**Re: Comments: Sydney Metro West - Westmead to Sydney CBD
Reference Number: #11426**

Thank you for the opportunity to provide feedback on the Exhibition Notification Sydney Metro West Stage 3.

Place Management NSW (Placemaking NSW) has reviewed the supporting documents available on the Department's website and offer the following high-level feedback. The following relates to the Bays Metro station component of the EIS:

Figure 15 Site plan - The Bays Station construction site

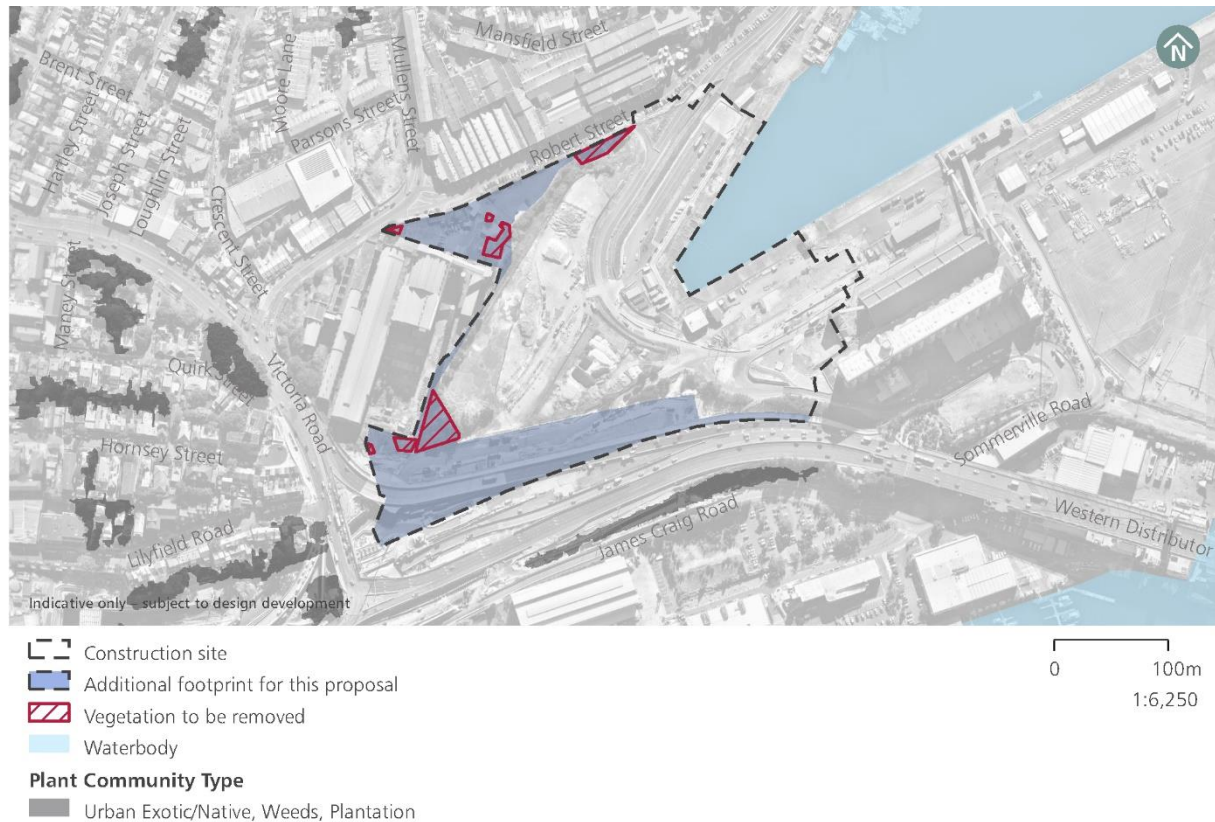
- EIS does not identify, nor take into account the State Heritage *curtilage* of WBPS but rather concentrates only on the building complex.
- Place Management NSW, as the land owners of the White Bay Power Station and its State Heritage Significant Curtilage, requests that it is involved in further design and development of the traction substation to ensure it does not obstruct the views of the Turbine Hall, Boiler House & Chimneys when viewed from the South and the Anzac Bridge.

- The Box culvert excavation for new drainage (2-4 meters deep) in the northern part of the construction site and piling work for the traction substation may have impact on the canal/water inlet-outlet and its function. Future design / development must take into account the impact and necessary involvement of the NSW Heritage Council. Plans to be shared with PMNSW to review and for endorsement.

- The proposal in the EIS has no provision for vehicle access to the WBPS site (Roberts Rd or otherwise).

- Road network needs to address the adaptive reuse, and therefore commercial viability of the WBPS; access to and from Rozelle Goods Yard and Roberts Street, and vehicular and pedestrian connectivity with Bays West Masterplan area.
- Additional Land for the precinct is limited to works and not development with the possible exception of the traction sub-station
